Barnham Parish Council

22nd April 2014

Approval of Reserved Matters following Outline Approval BN/15/11 for Appearance, Landscaping, Layout and Scale. Departure from the Development Plan and Affects a Public Right of Way.

TREE CONSTRAINTS KEY

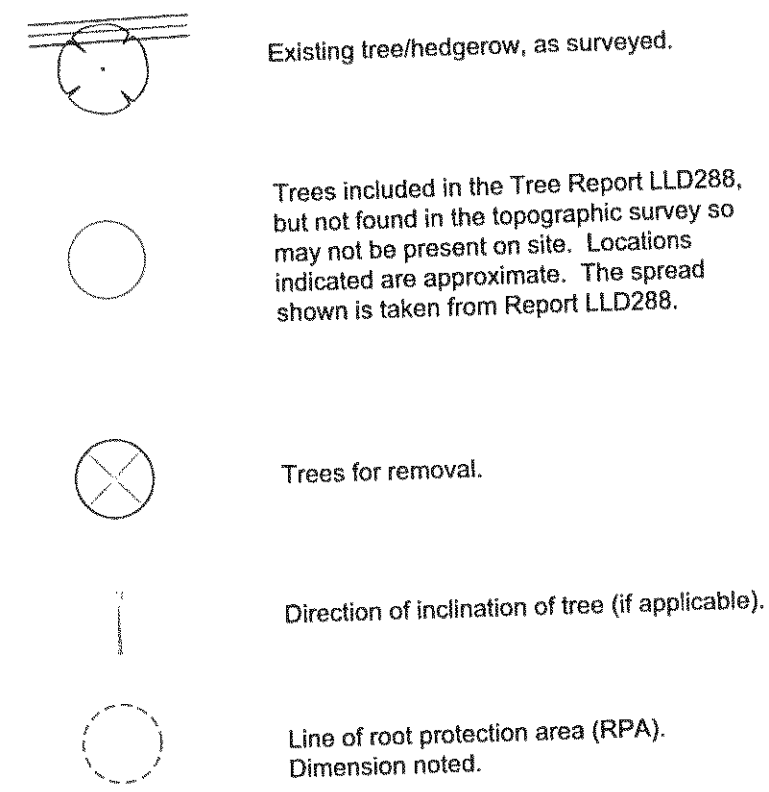
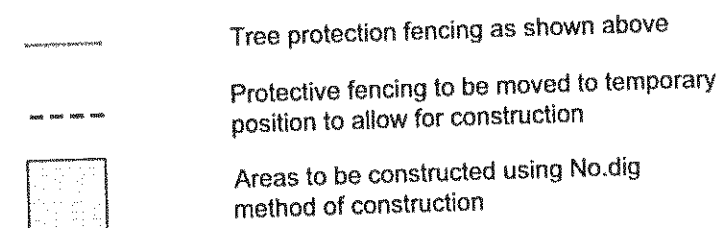
It has also been brought to the Parish Council's attention that trees and hedgerows have recently been felled or taken down on the proposed site, this is during the nesting season, which is an offence under the Wildlife & Countryside Act 1981 as detailed below:

The Neighbourhood Plan also contains a policy ES9 – Trees and hedgerows will be protected. This action can be seen to be in contravention of this policy.

Landscaping - Typical Plots

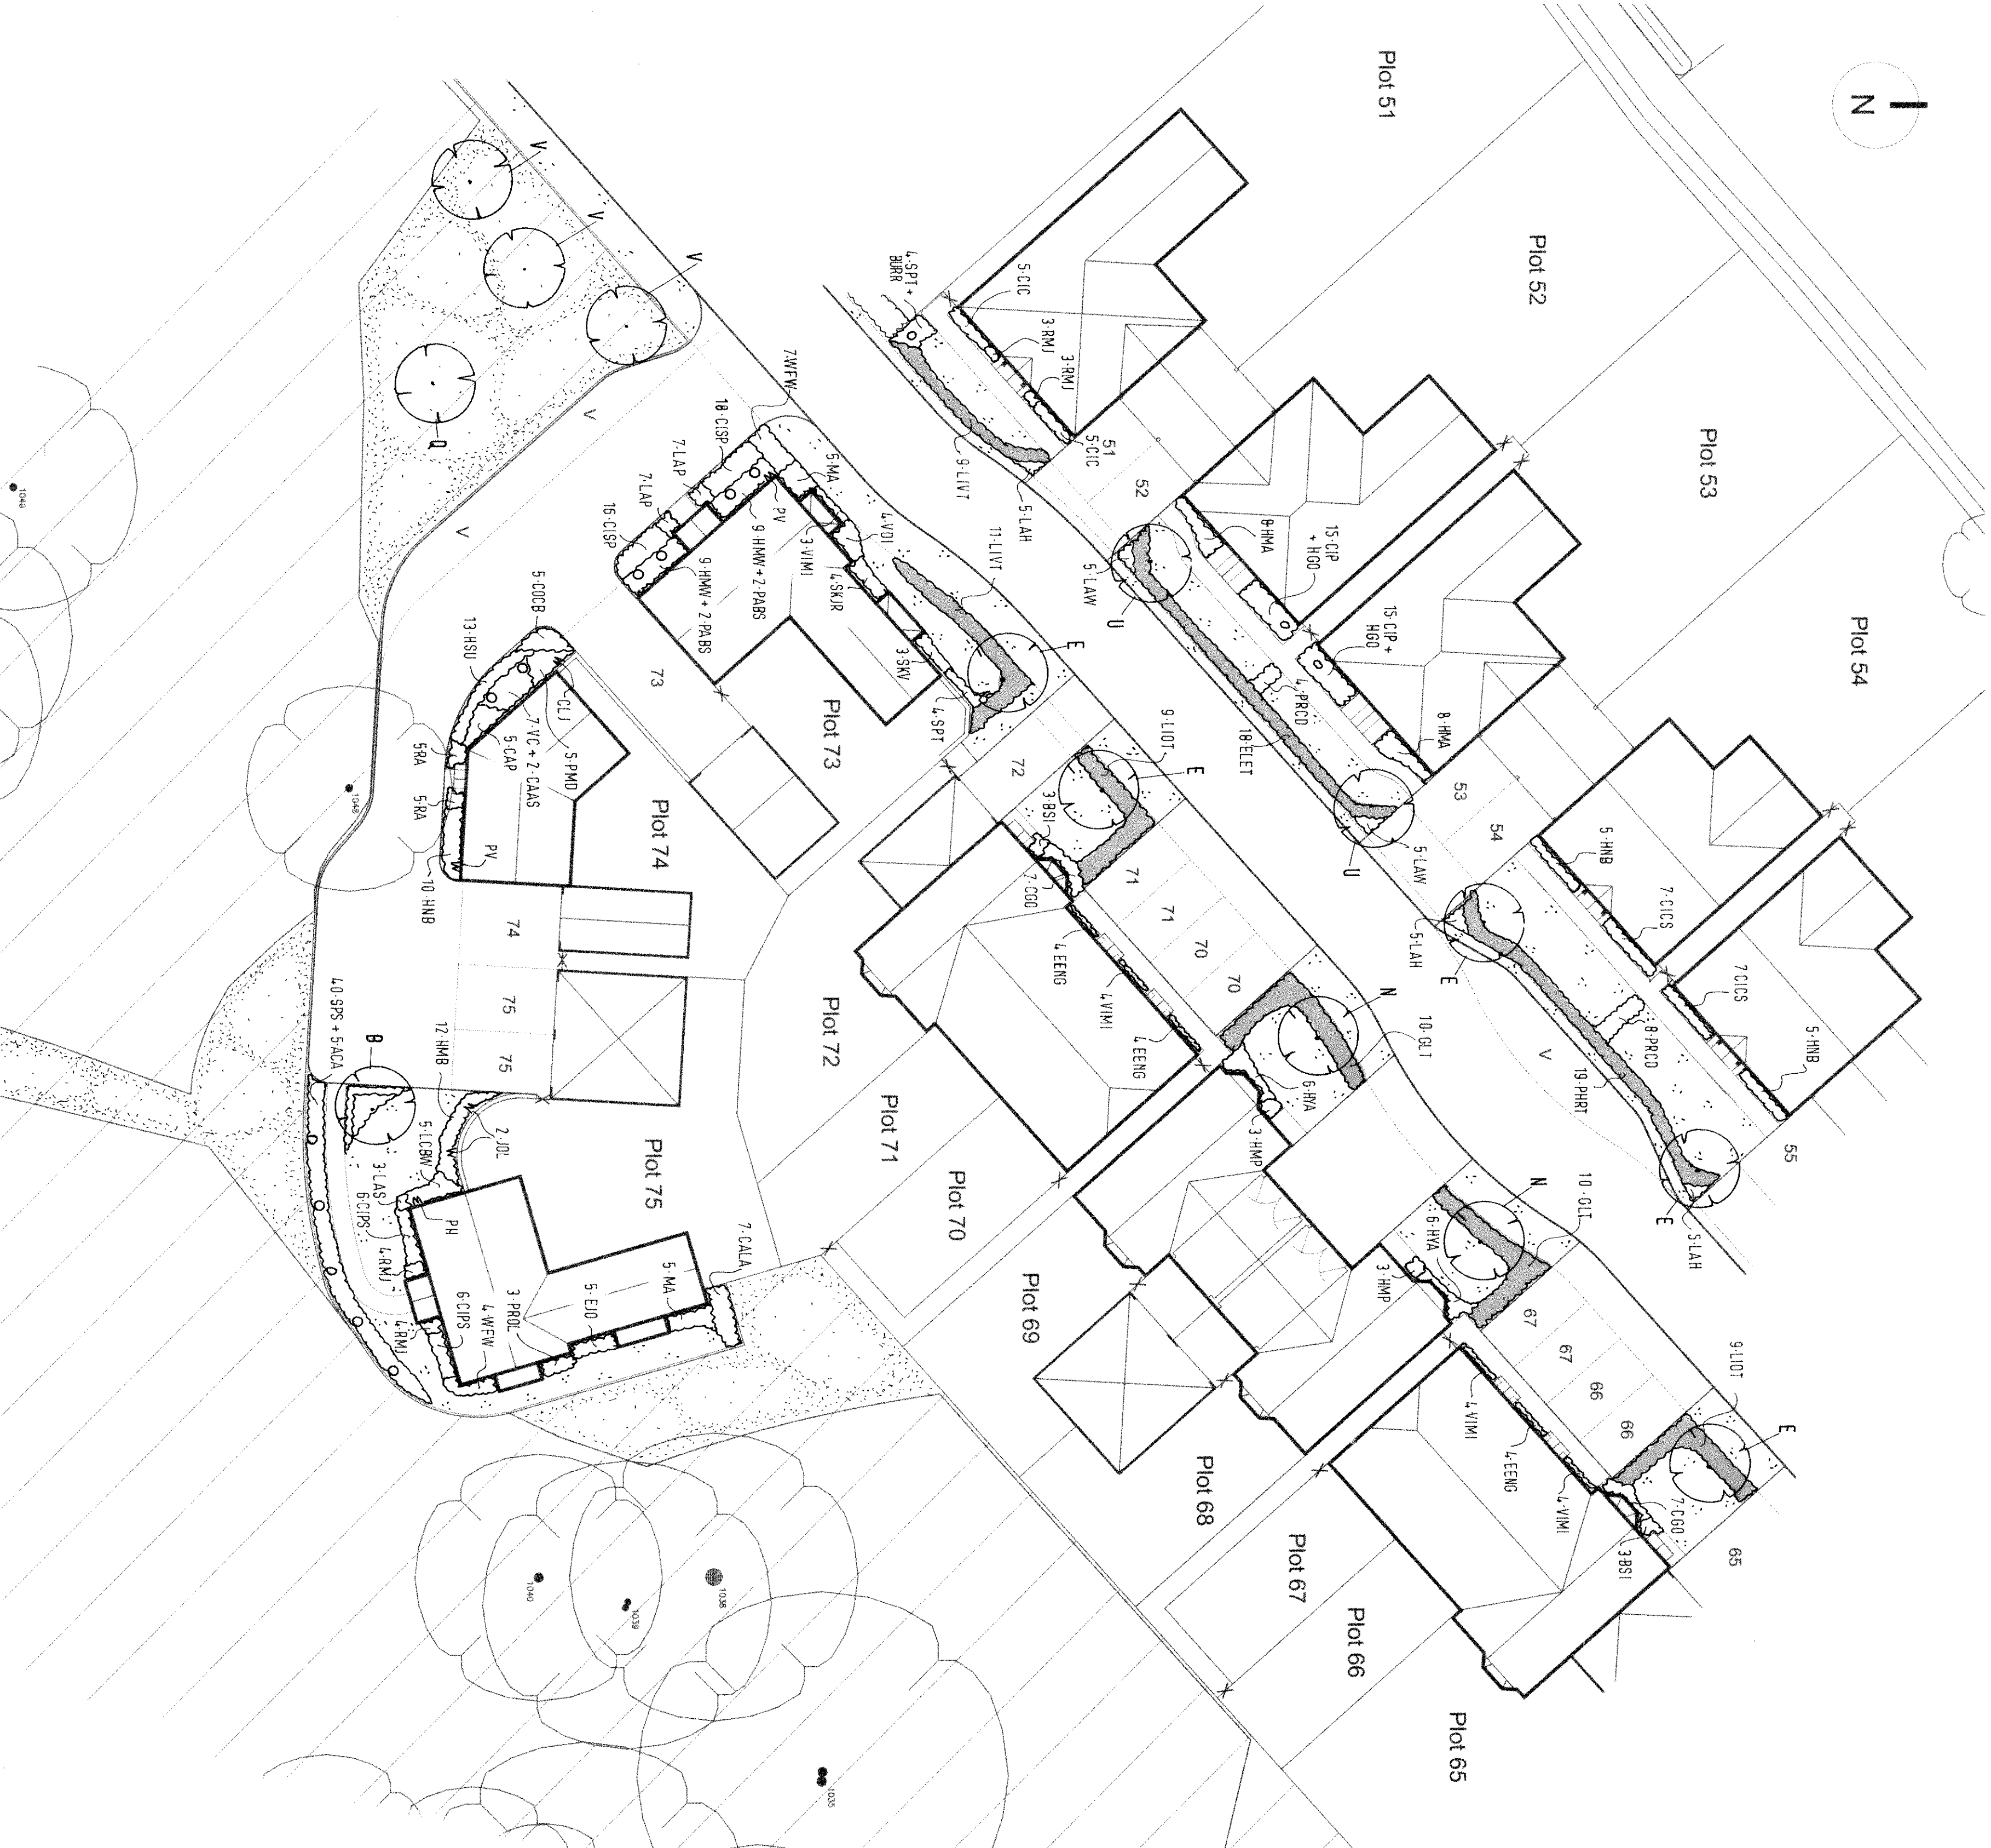
Finally, the original plans showed screen planting along the footpath between the site, the Public Right of Way and ultimately the neighbouring properties in Halliford Drive. The new plans show no such screening and the Parish Council would ask for evidence that adequate fencing or screening would still be part of the scheme to ensure both protection of the footpath, a very well used amenity, and also afford some screening to the neighbouring properties in Halliford Drive.
